Application No: MP07_0158 MOD 3

Exhibition of Modification Request for the University of Sydney Abercrombie Precinct Redevelopment

Date: 10 November 2013

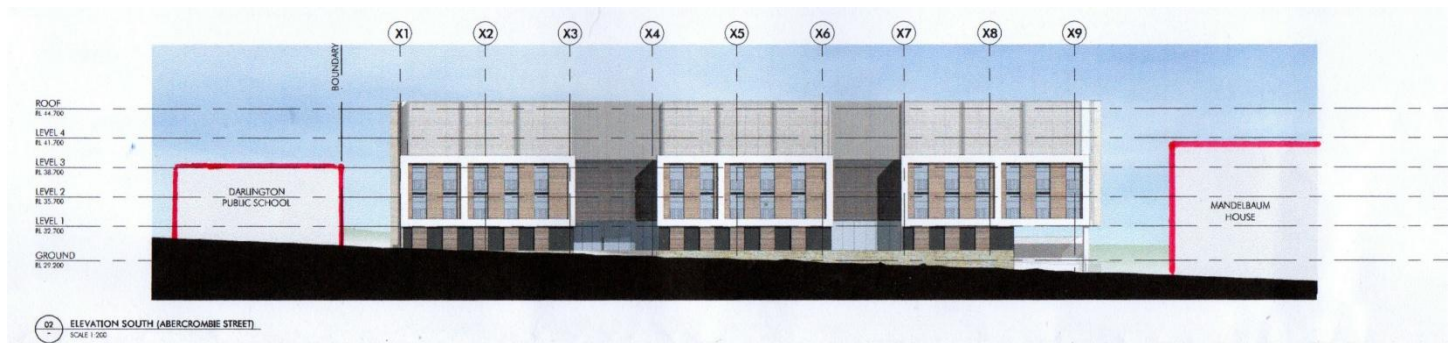
- The people walking along the street in the picture would only just fit into the rooms on the ground floor. It appears as though the building would be built below ground level. However, this is not the case.
- The Darlington Public School building in the left of this picture is a 2 storey building yet appears to be the same height as the 5 storey Student Accommodation next door.
- The University's own picture below gives a truer idea of the way in which the Student Accommodation would be much higher than the Darlington Public School building to the left and also Mandelbaum House to the right.

- The University's own elevation below clearly shows that Darlington Public School, outlined in red on the left of the picture, is a 2 storey building which sits well below the 5 storey Student Accommodation.
- The red line at the top of Mandelbaum House on the right of the Student Accommodation is actually the height of its pitched roof.

Once again, it appears that the University is not being completely honest with residents by misrepresenting the 3D rendered image above in order to make the building appear much smaller than it would actually be.

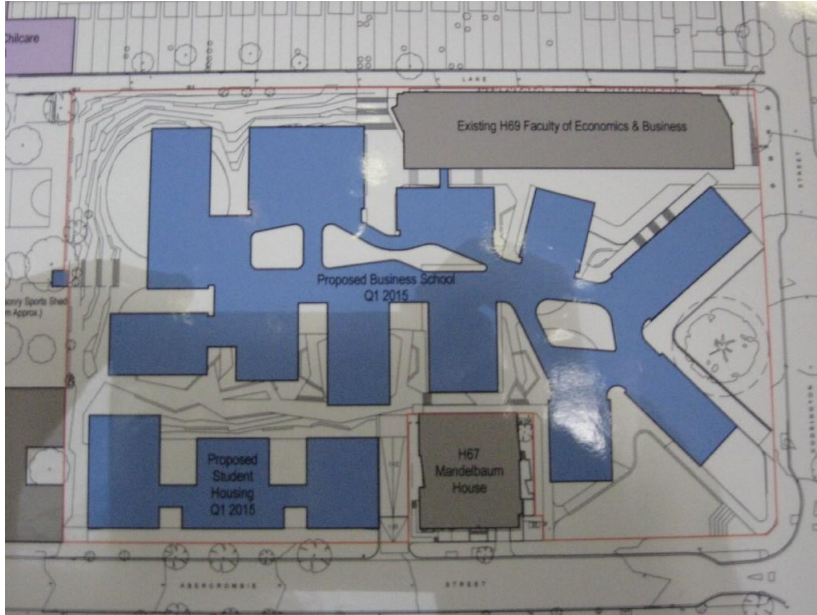
Many objections made to the original plans for the APD Business School and Student Accommodation buildings were on the basis of their height, bulk and scale, especially as they are proposed to stand much higher than Mandelbaum House to the east and Darlington Public School to the west, dwarfing both of them.

The scale of the proposed Student Housing building along Abercrombie Street is up to five storeys, which is out of character with the prevailing height and scale of the 2-3 storey Victorian terraces on the southern side of Abercrombie Street and a number of other traditional buildings mainly located at the intersection between Abercrombie Street and Codrington Street.

It is also out of scale with Mandelbaum House, which was designed to complement the Abercrombie Street streetscape.

One of the prerequisites of the planning authority at the time of the construction of Mandelbaum House was that it reflect the scale and look of the existing buildings in Abercrombie Street – terrace houses of 2-3 storeys. That is why Mandelbaum House was designed as a three storey building along the Abercrombie Street frontage with the fourth level set well back from the street. Mandelbaum House, at three storeys in height along the street, sits comfortably in the existing streetscape and is consistent in scale with the 2-3 storey terraces.
